WEST SUSSEX COUNTY COUNCIL CONSULTATION

TO:	Arun District Council FAO: Maria Tomalova
FROM:	WSCC - Highways Authority
DATE:	3 August 2022
LOCATION:	Land at rear of Cedar End Eastergate Lane Eastergate PO20 3SJ
SUBJECT:	BN/65/22/PL Sever land and erection of 1 No bungalow with new vehicular access (resubmission of BN/14/22/PL). This application is a Departure from the Development Plan and is in CIL Zone 3 and is CIL Liable as new dwelling.
DATE OF SITE VISIT:	n/a
RECOMMENDATION:	More Information
S106 CONTRIBUTION TOTAL:	n/a

Land r/o Cedar End, Eastergate ^ Maximum Visibility Splays ^ 1:2000@A3 ^ 1671-SYM-00-ZZ-DR-A-0214 P01

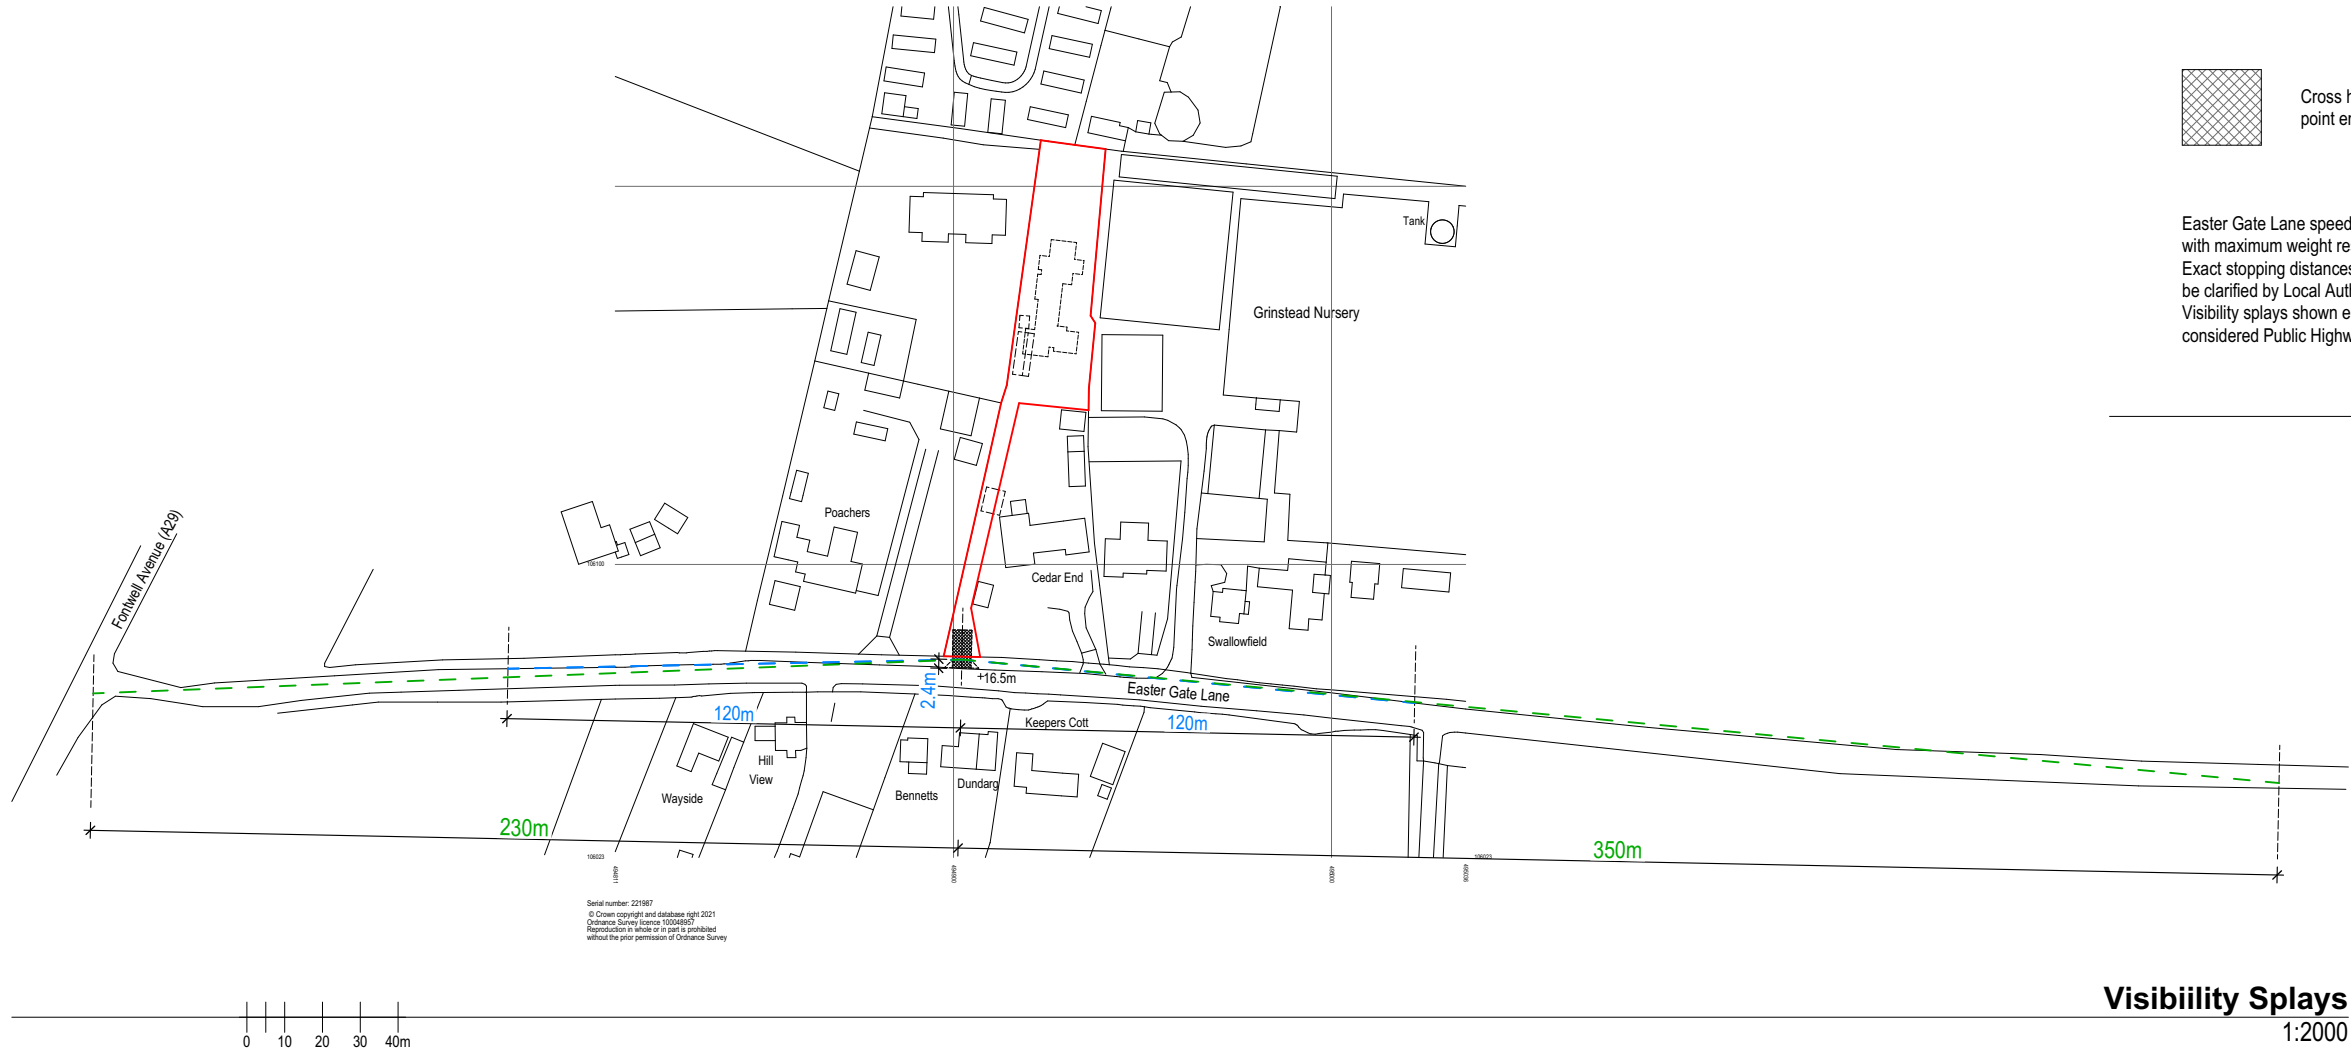
The LHA do not believe that the current supporting evidence demonstrates a safe and suitable access. The LHA therefore requests the applicant provides the following information.

1. A 7 day speed survey to determine the 85th percentile road speeds and supporting maximum achievable vehicle visibility splays that should be located within land under the applicants control or the highway boundary
